Jeanie Bourke - Re: 616 Congress ST., B#2015-01687 plan review comments

Good Afternoon Thomas and Buell,

I have completed the review of the above project for building code and have the following comments as noted on the attached file(s).

Basement Floor Plan

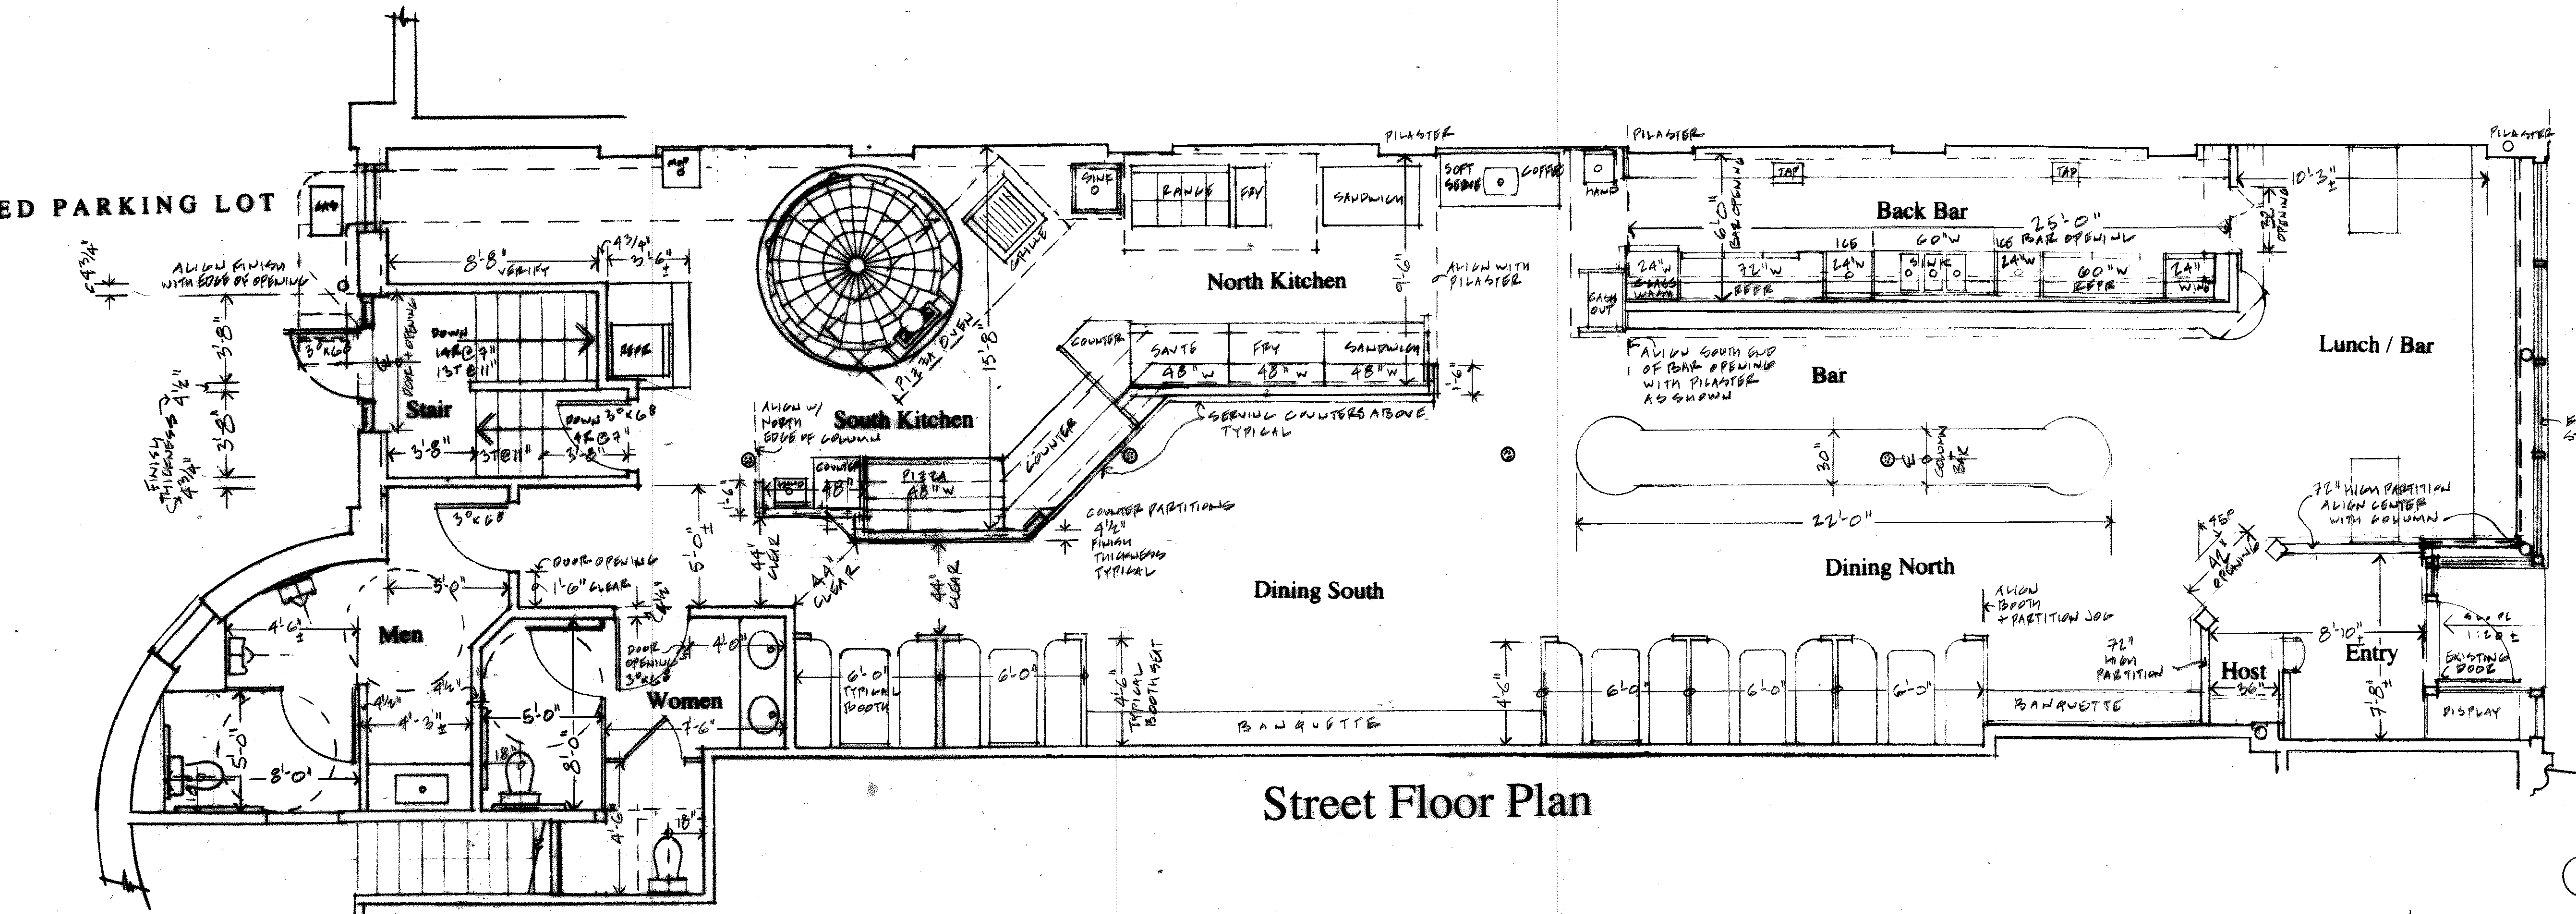
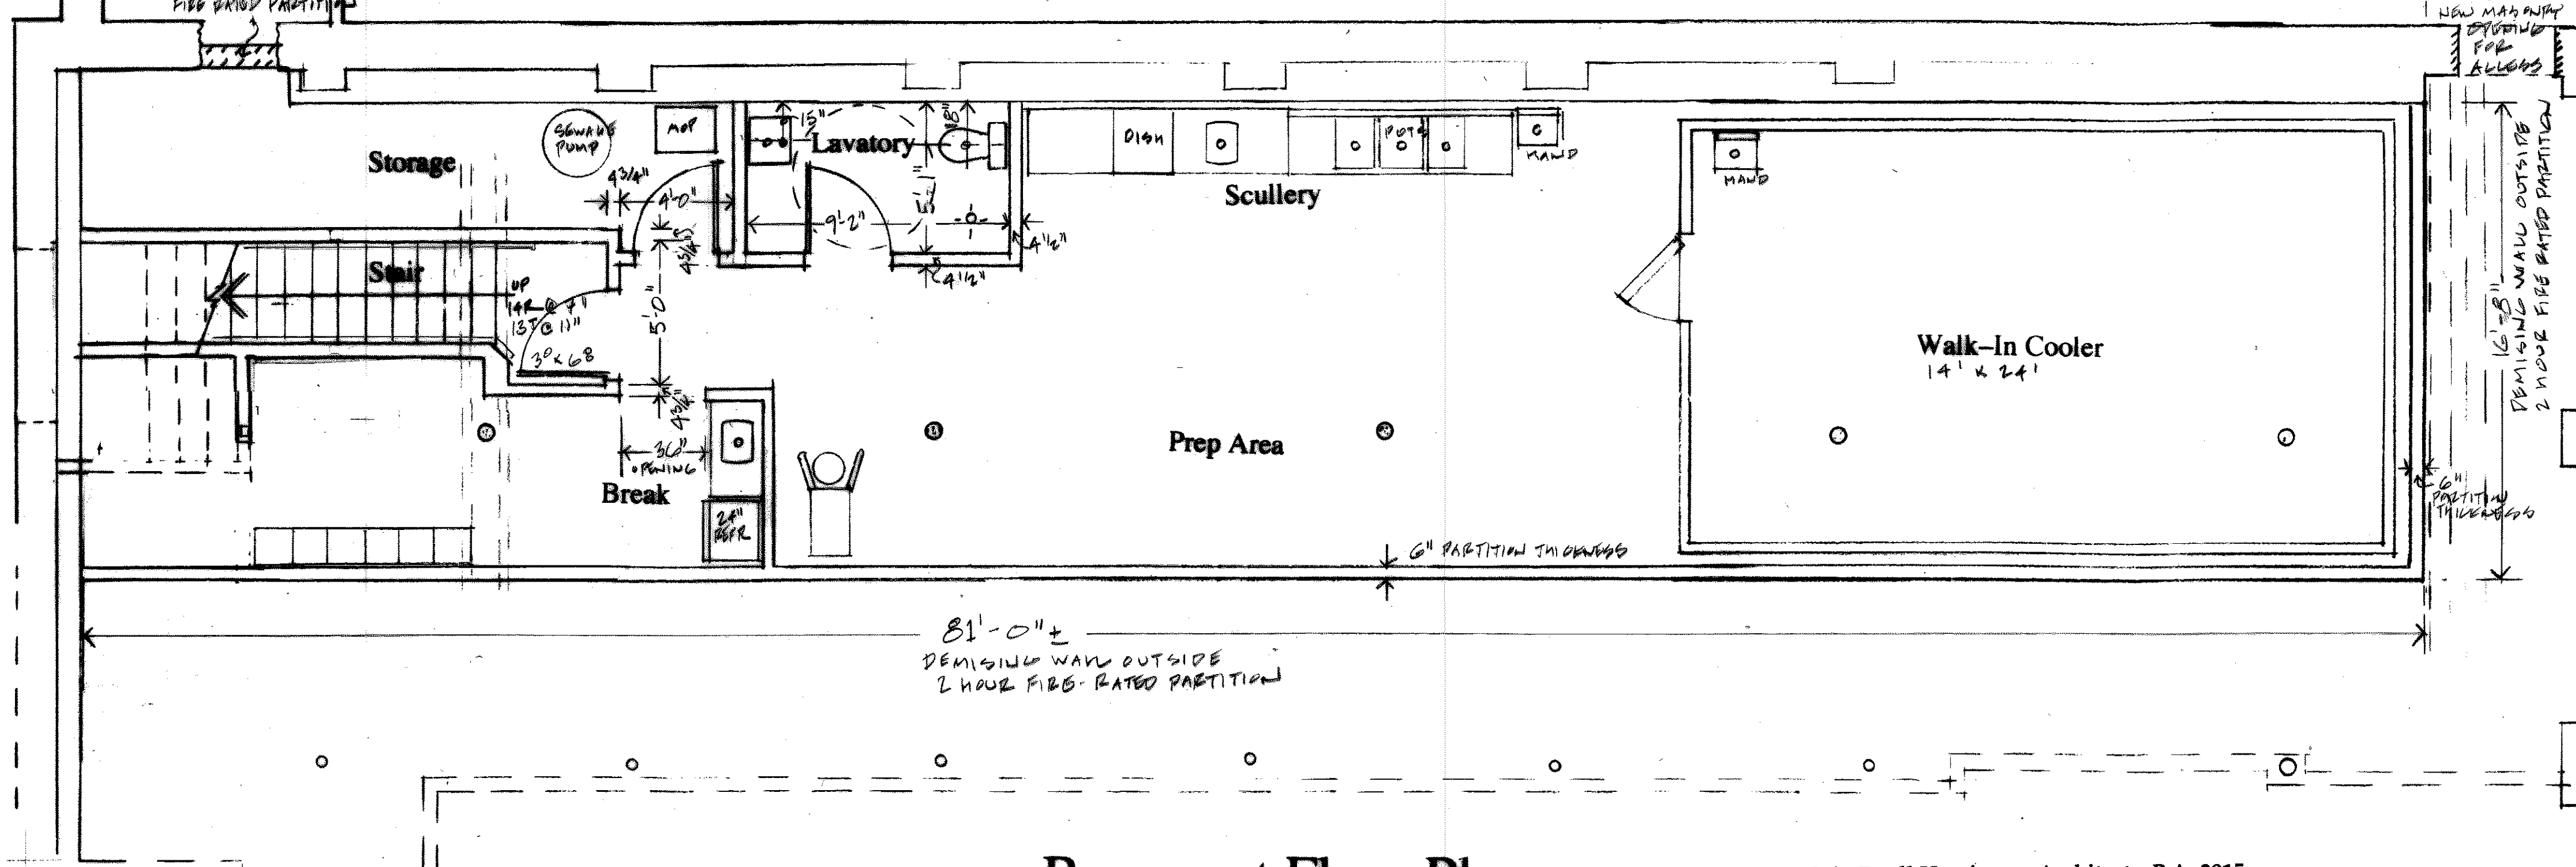
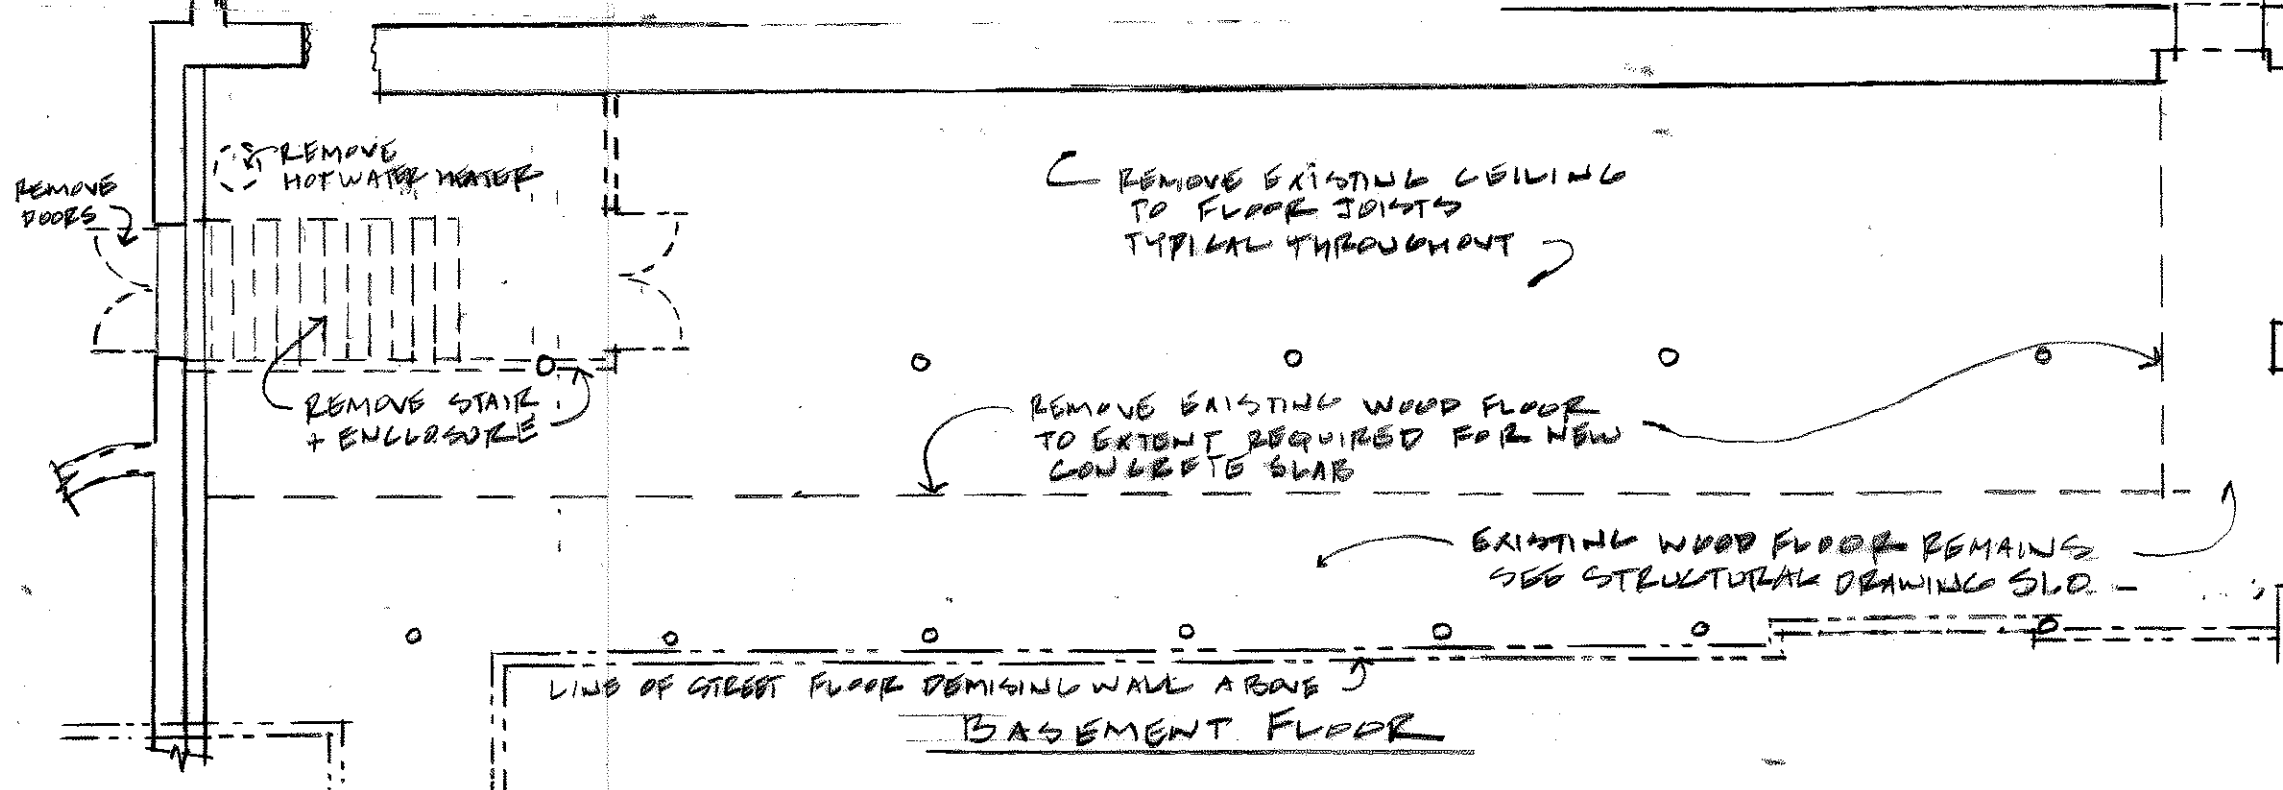
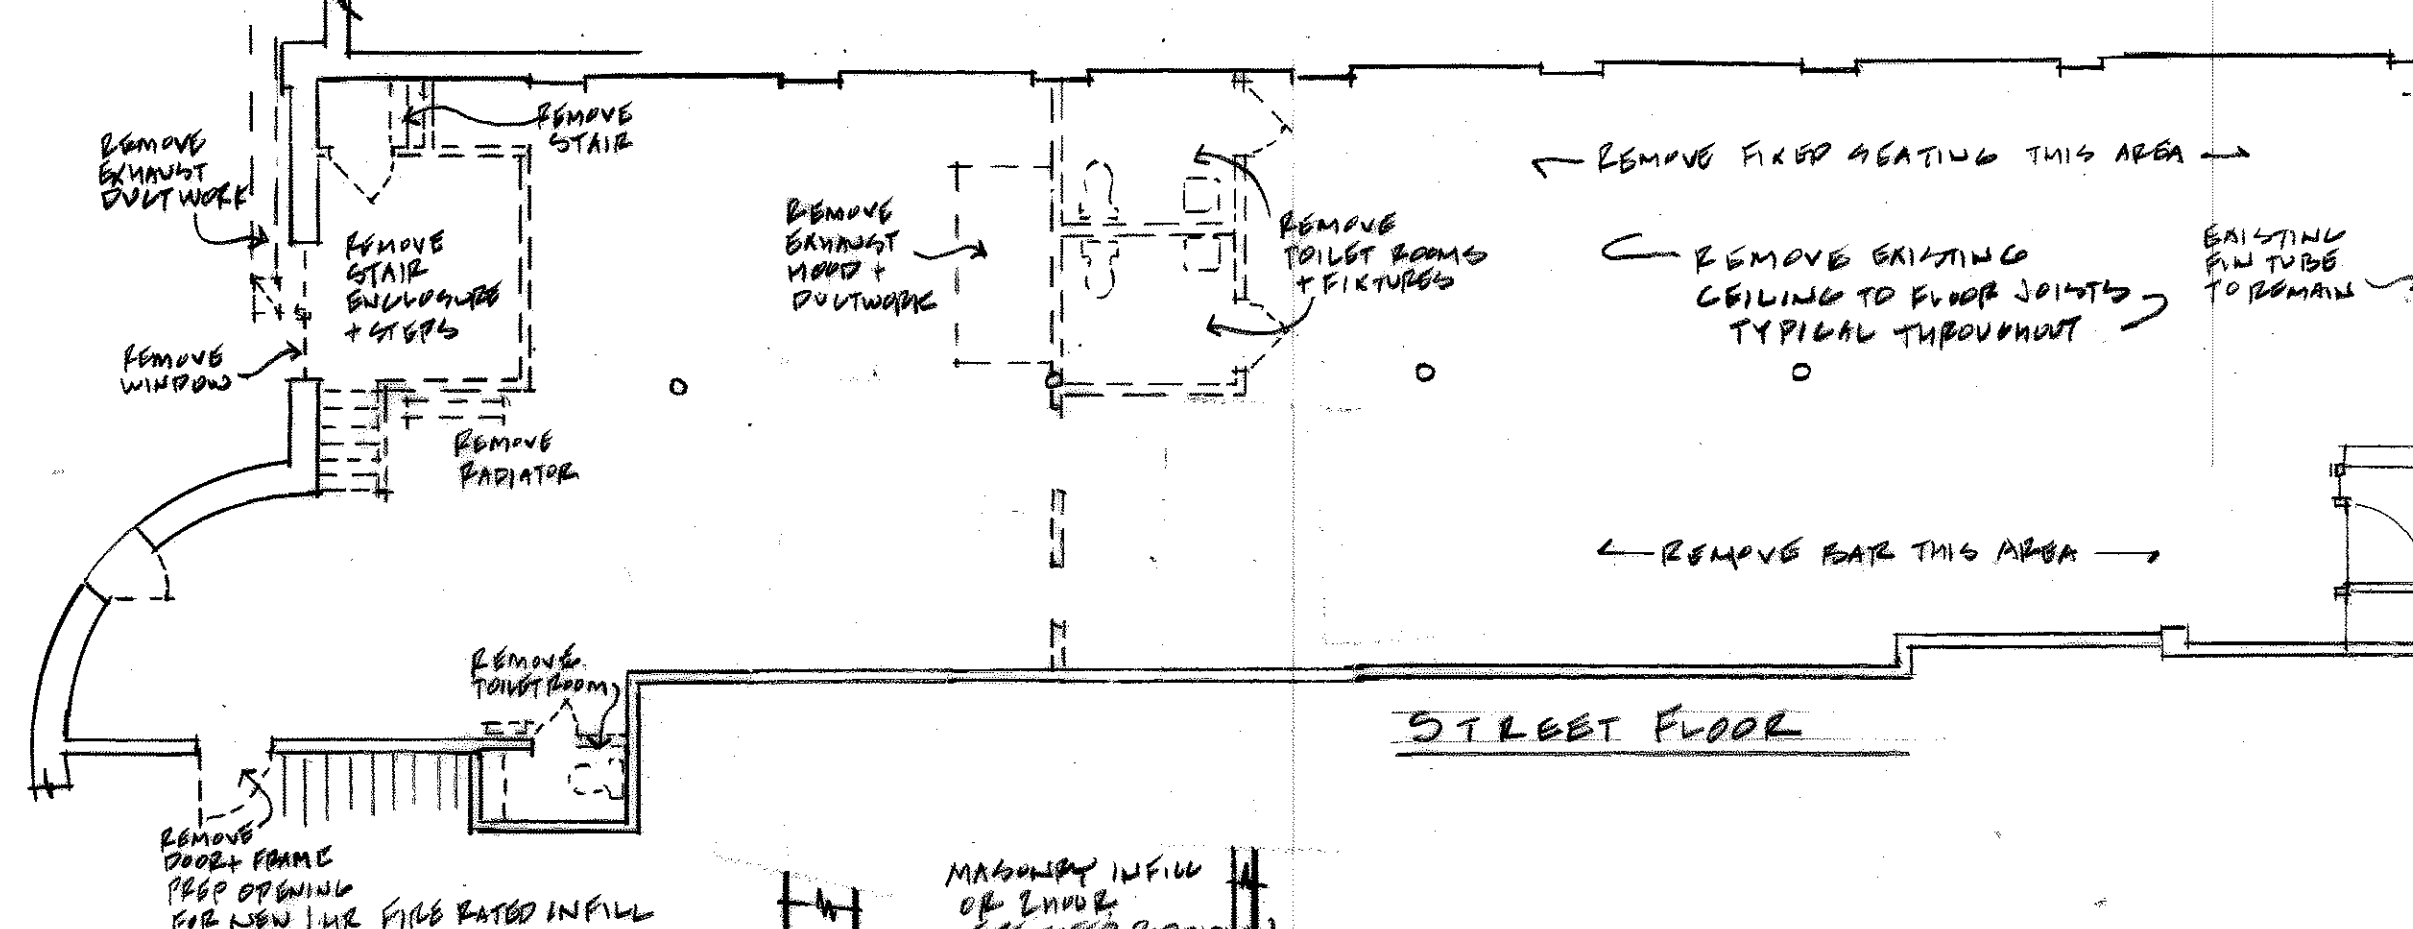
- The open food prep area downstairs is somewhat intentionally left open, we have tentative plans for the future but it depends largely on variances in the health code from the State that we are working on. It wouldn't have anything more than wire shelves and prep tables initially.

- The bar behind the bar was meant to deal with bar overflow and larger parties. I am not even sure that it will be exactly built in initially it may be high top tables occupying the same footprint at first. I'm sorry that this probably doesn't answer your question but that is our intention for that space, it would have stools, but be bar/standing height.
